**Consultation Response from KC,
Conservation & Design**

2026/90619 United Church Marsden, Warehouse Hill Road, Marsden, Huddersfield, HD7 6AB

Change of use and alterations to church (class F1) and Sunday school to form 8 residential units (class C3), including internal reconfiguration and external alterations, insertion of rooflights and formation of roof terrace, associated parking, landscaping and ancillary work. (within a Conservation Area)

Date Responded: 6/5/26

Proposed Site Plan
Scale 1:200

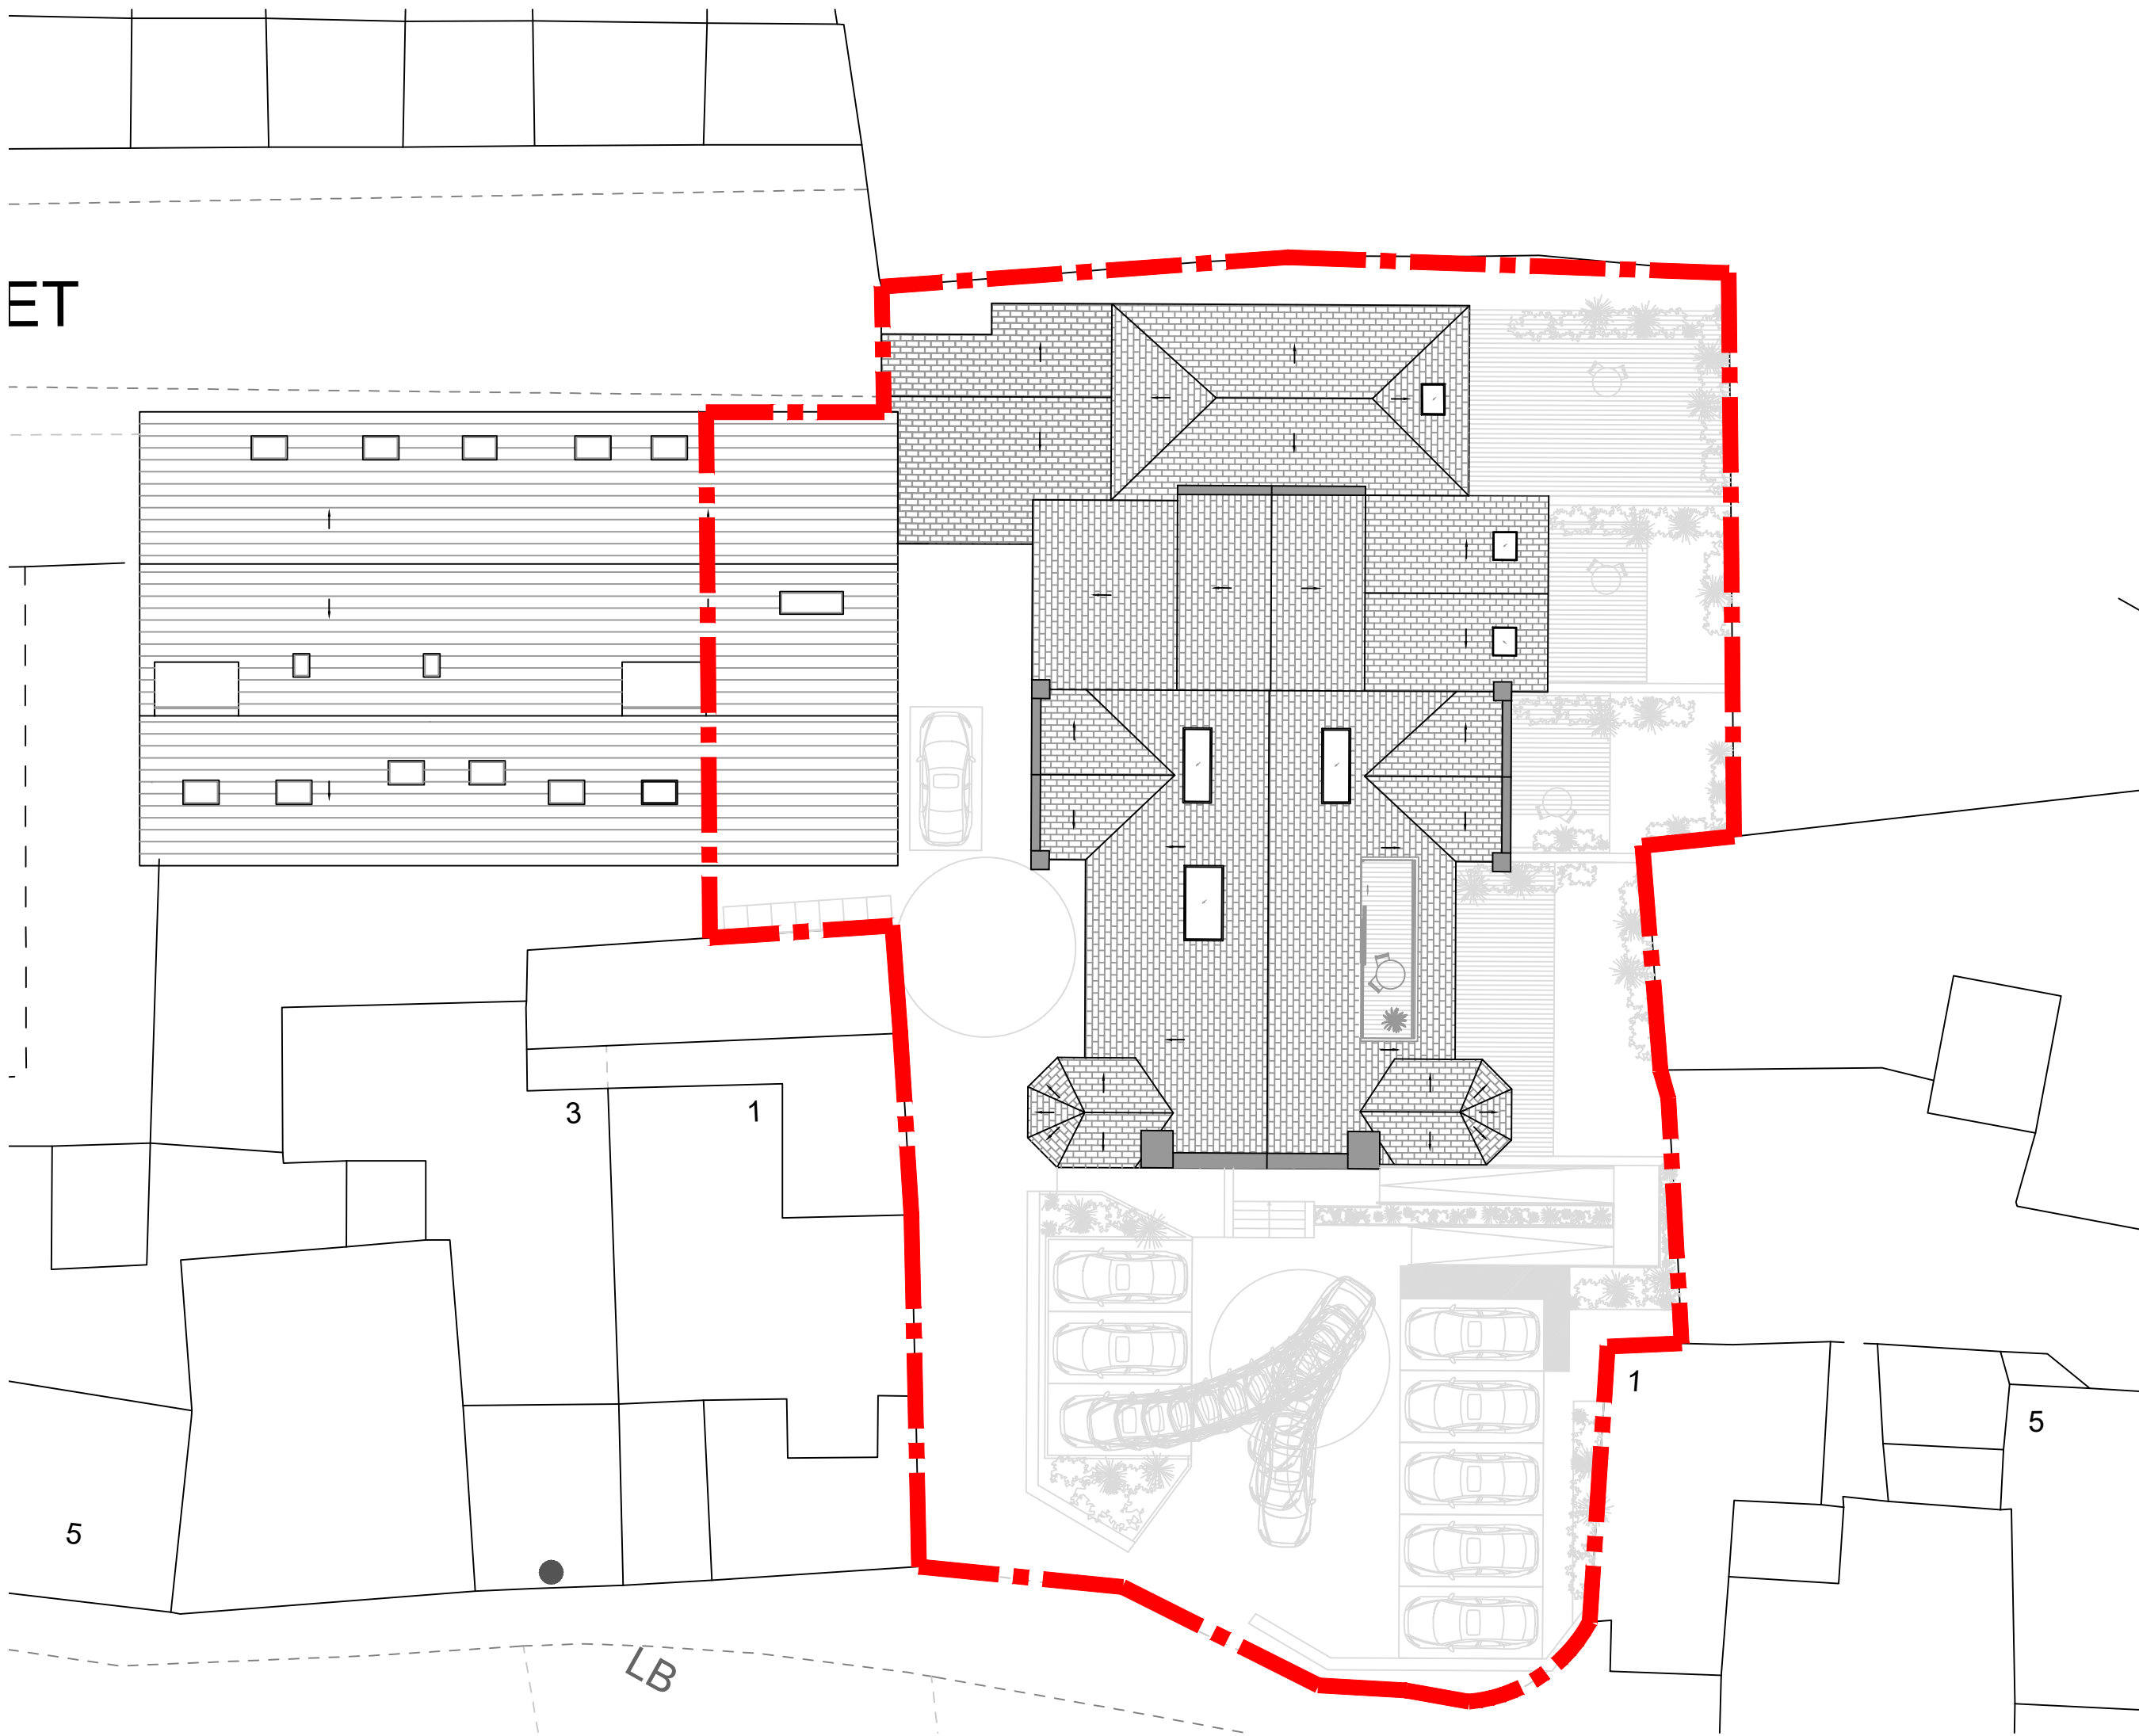
The front elevation is completely symmetrical, with imposing stone steps, walls and railings to the large entrance door. The proposed new ramp to the right side of this front elevation will introduce an asymmetrical feature. It will be important to condition matching natural coursed stone to be used for the retaining walls of the new ramp, a suitable surface to match the colour and palette of materials of the church, and quality metal railings and handrail to complement the existing railing. Some more appropriate soft landscaping could be encouraged to the immediate frontage of the front ramp as well to reduce the impact of the large new ramp.

Stone boundary walls should be retained to provide a strong boundary treatment and sense of enclosure in keeping with the building and Conservation Area. Appropriate hard and soft landscaping is recommended. Stone paving would be more appropriate and longer lasting than timber decking.

title:
Proposed Site & Roof Plan

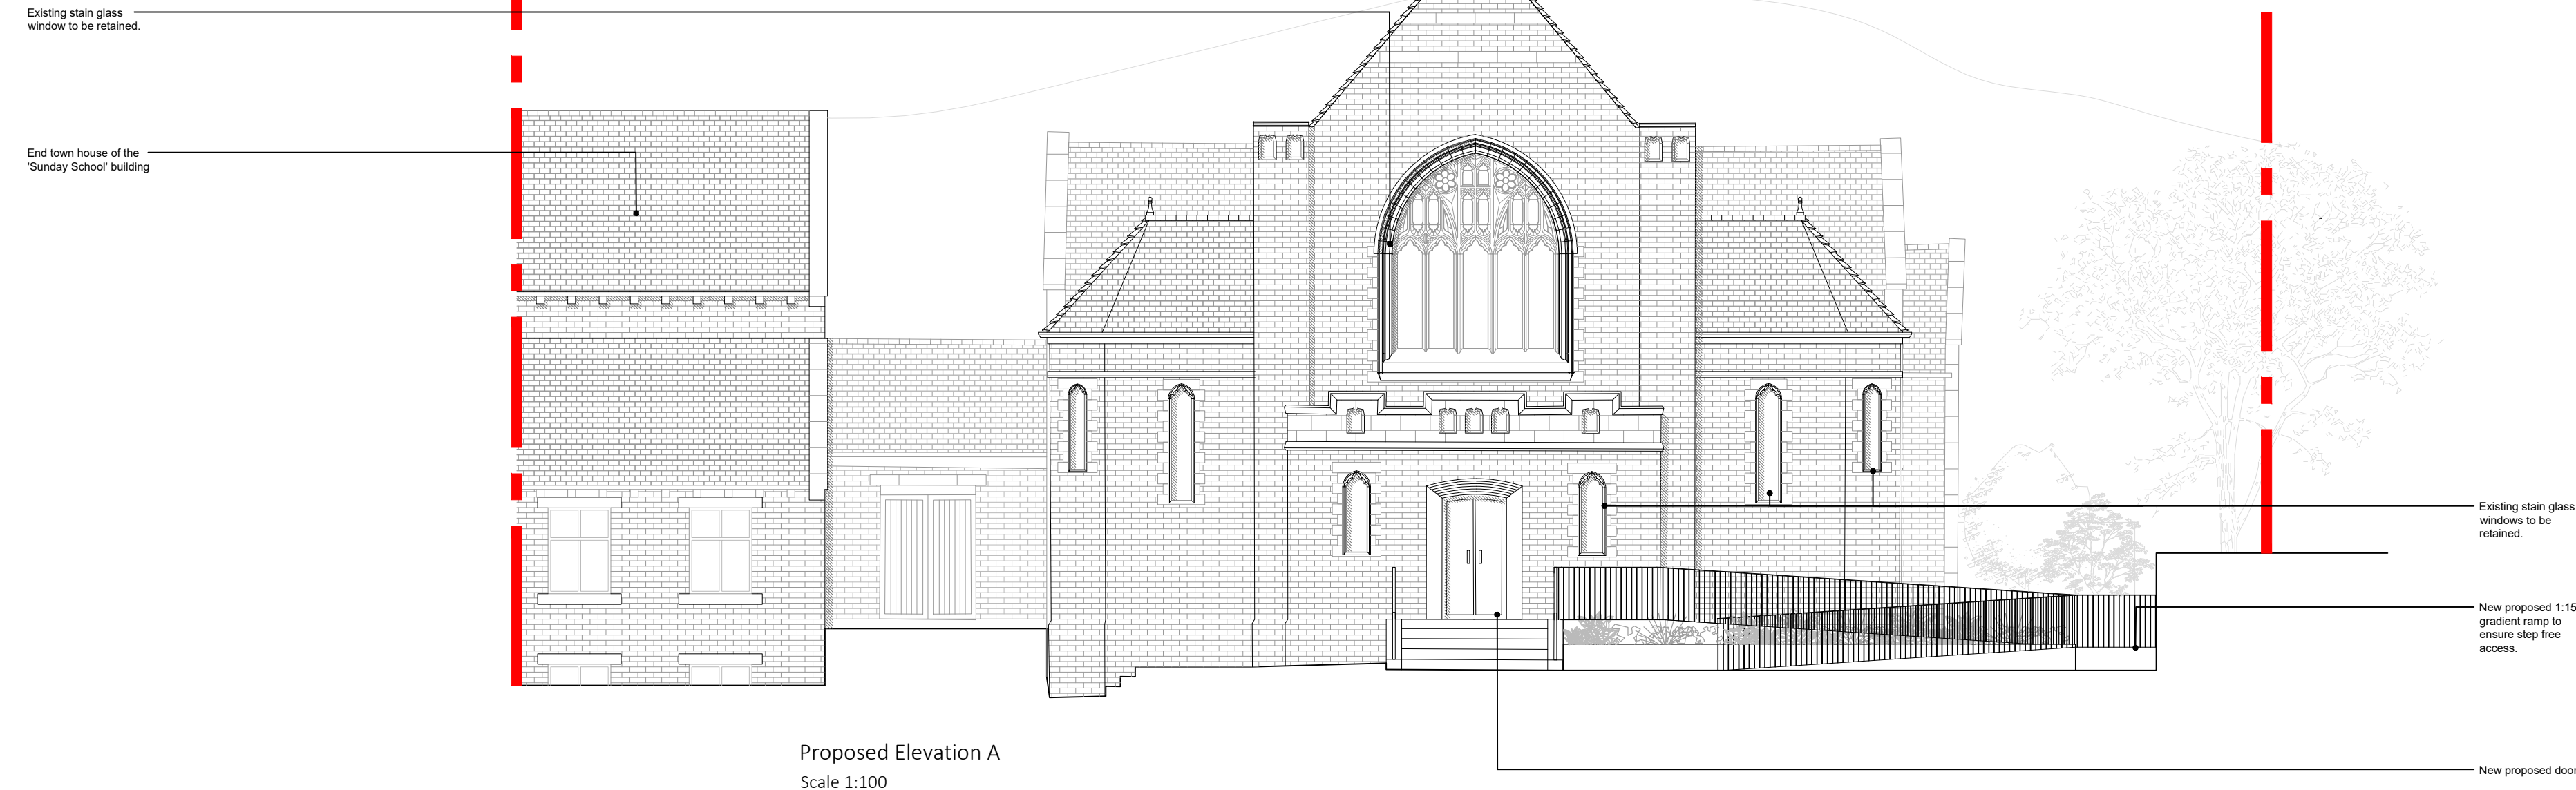
The large roof lights in the top floor should be reduced in width and should be placed symmetrically above the large gable below. All rooflights should be flush with the roof slopes and use a Conservation type roof light with dark surrounds.

This is a large feature within the roof. It should be reduced in width and placed symmetrically above the 2 arched windows below. The glass balustrade should ideally be set within the recessed structure if possible.
